City of Albuquerque Stormwater Construction Site Inspection Report

General Information									
ESC File No.		B18E022		Project Name:		Venice Volleyball Complex			
NPDES Id. No.		NMR1006A0		Location:		5801 Venice Ave NE			
8/8/2024		Owner				Contractor			
Operator		Verde Management							
Contact name & title		Craig Erdman							
e-mail		ckeconstructionllc.com							
Contact Phone #		505-907-1715							
COA Inspector		Chancellor English				Start/End Time:		2pm	
Construction Phase:		verticals							
Type of Inspection:		Regular		Storm Event		Post Storm Event >0.25"		311/Complaint	
Weather at time of inspection?		Clear				Temperature: ~		97	
Estimated date of last storm 0.25" or greater						7/21/2024

EROSION AND SEDIMENT CONTROL PLAN

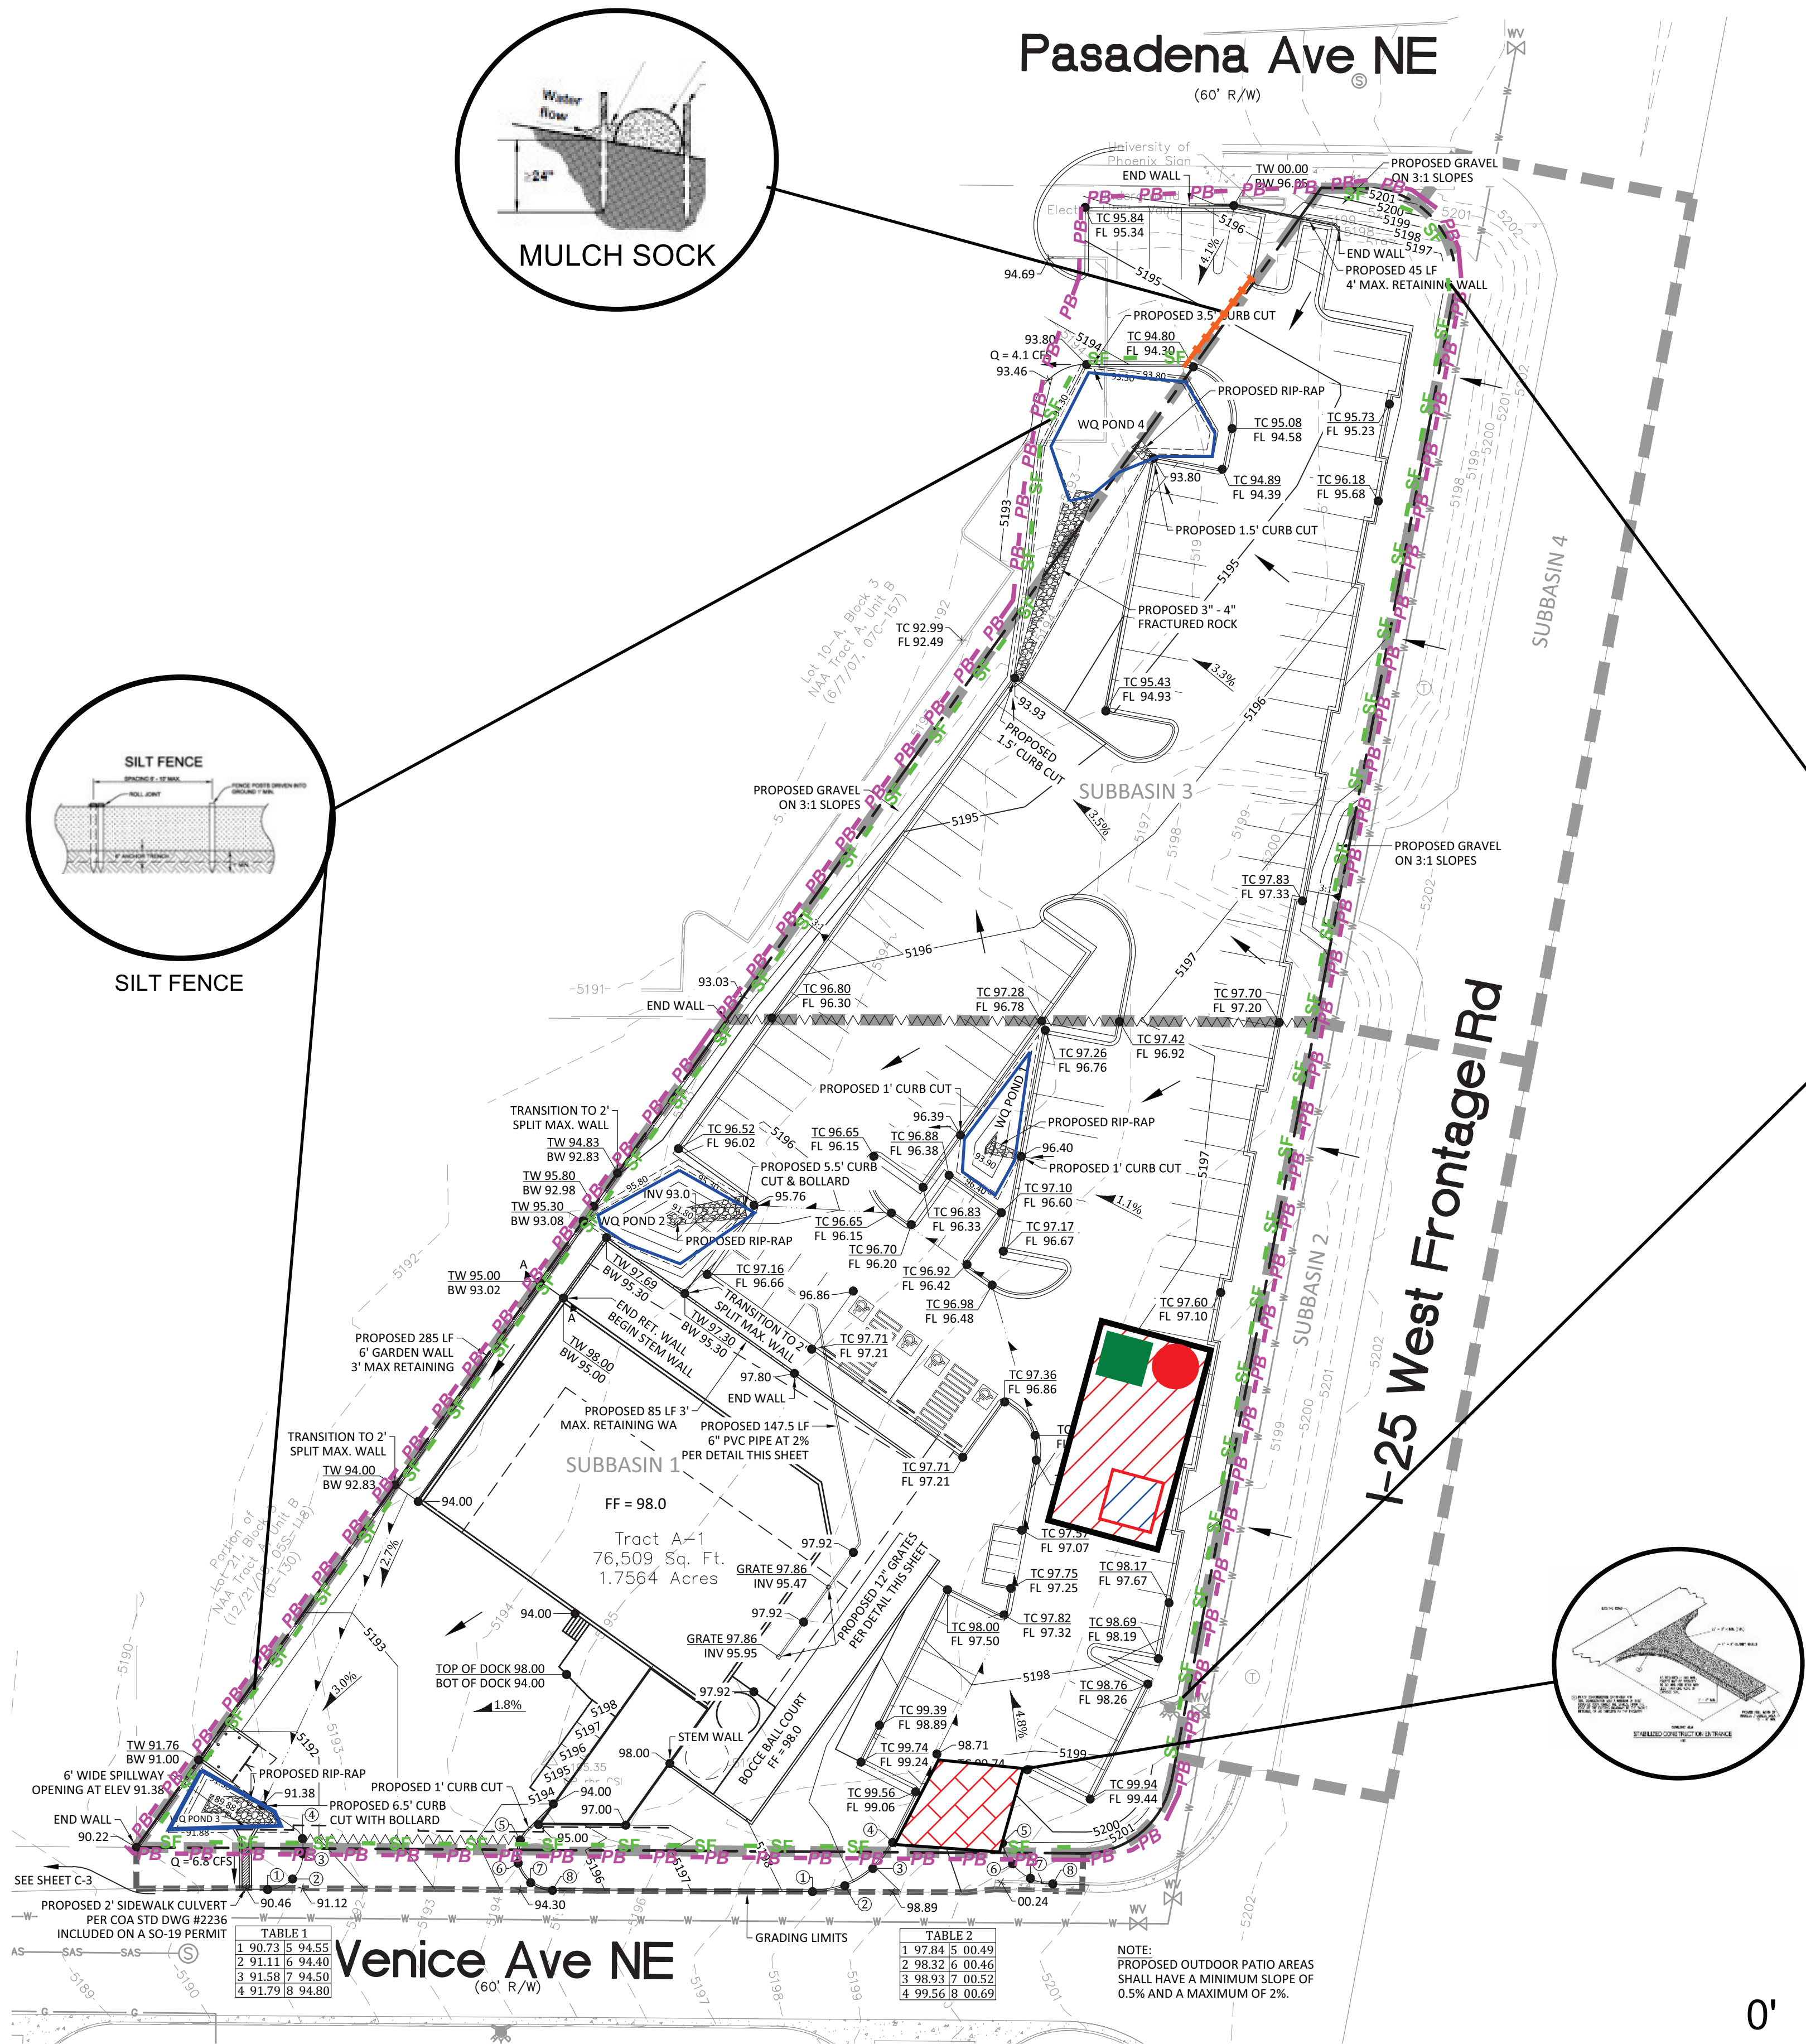
Item Number	Deficiency/ Corrective Action								
1	Posting - Your permit coverage posting was missing in violation of CGP Part 1.5. Required mitigation: You must post a sign or other notice of your permit coverage at a safe, publicly accessible location in close proximity to the construction site. The notice must be located so it is visible from the public road that is nearest to the active part of the construction site, and it must use a font large enough to be readily viewed from a public right-of-way per CGP 1.5								
2	The SWPPP and self-inspection reports were not available at the site in violation of CGP Part 4.7.3 and 7.3. Required mitigation: You must keep a current copy of your SWPPP and all self-inspection reports at the site or at an easily accessible location so that it can be made available at the time of an on-site inspection per CGP Parts 4.7.3 and 7.3.
